Your ref:	7 Bryanston Mews West	<b>Please reply to:</b>	<b>Central Planning Team</b>
Our ref:	21/03714/FULL	Tel No:	2514
		Fee Queries:	0207 641 6500;
		Email:	planningreception@westminster.gov.uk;
Mr Oliver Hacke The Structure Studio Ltd 45C Lansdowne Crescent Leamington Spa CV32 4PR		<b>Incomplete Applications</b> Development Planning City of Westminster PO Box 732 Redhill, RH1 9FL	
			11 June 2021

**Address: 7 Bryanston Mews West, London, W1H 2BW**

**Proposal: Installation of new side hinged garage doors.**

PROPOSED FLOOR PLAN

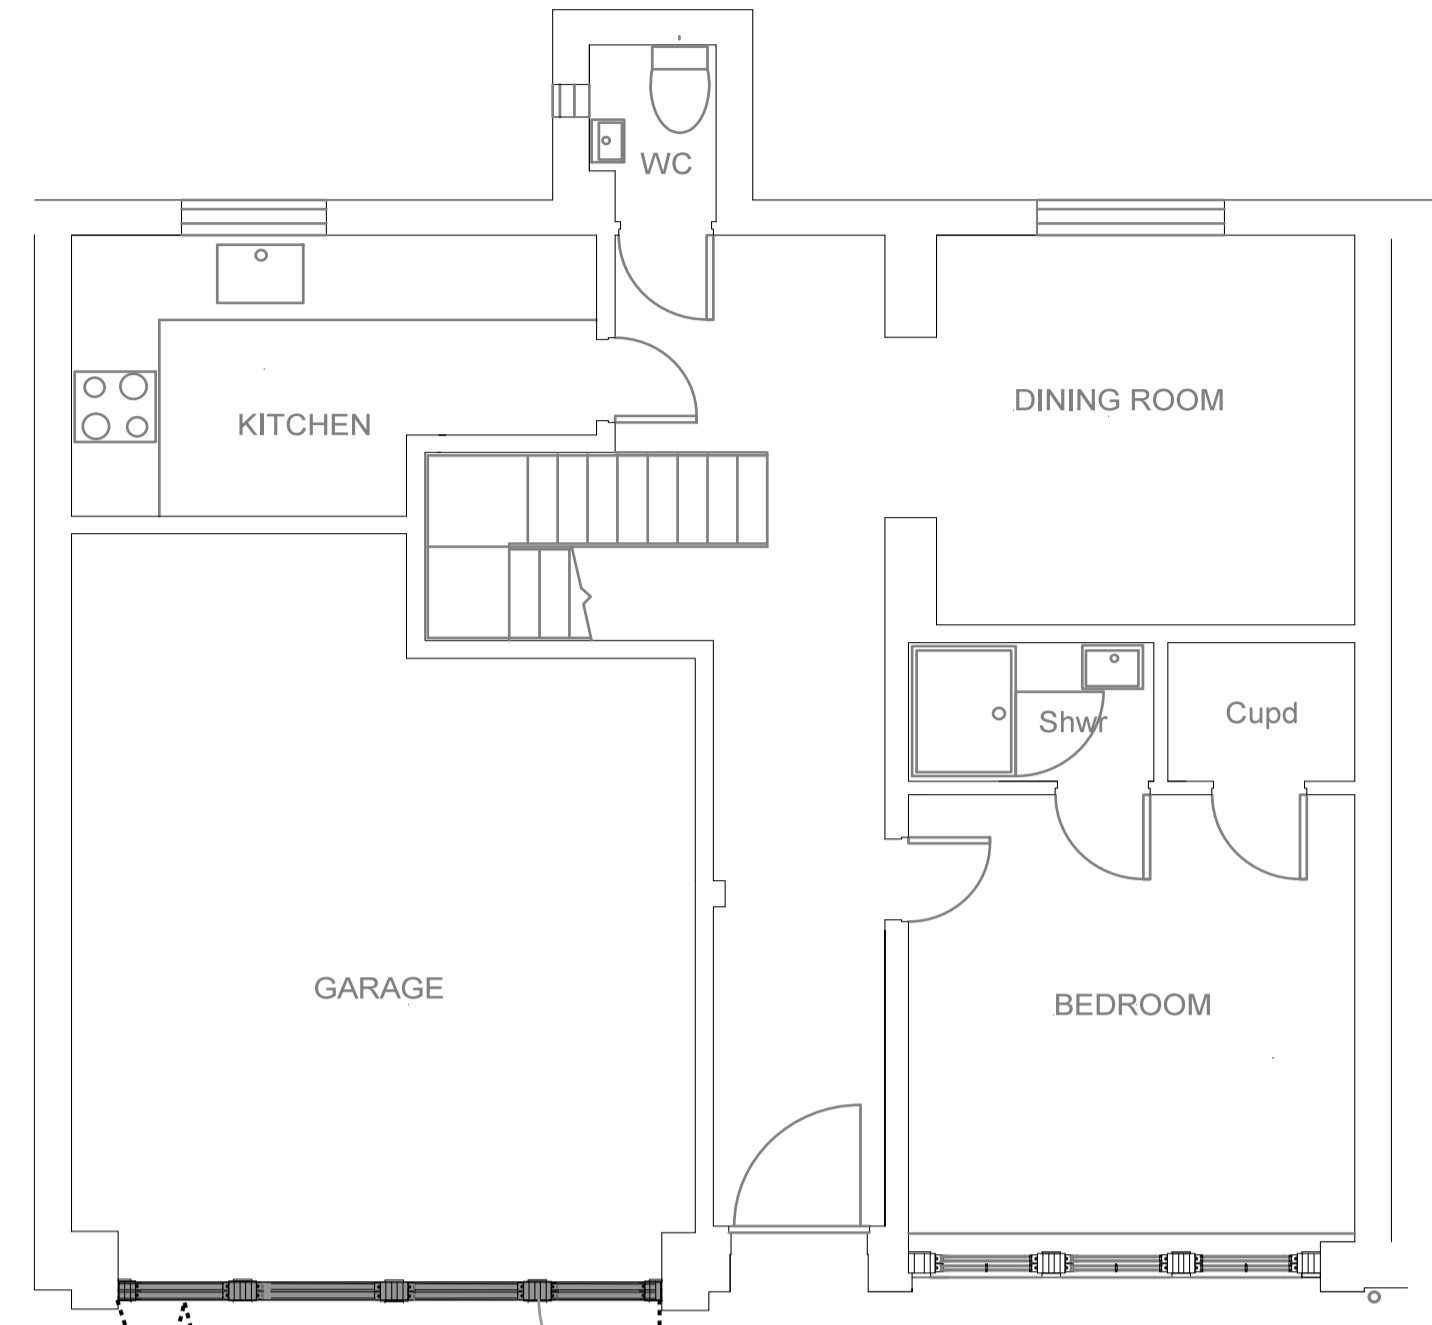
- 1 Please can the proposed ground floor plan drawing be updated to show the 'swing' of the new doors. You are advised that there may be issues in relation to garage doors opening outwards over the public highway.
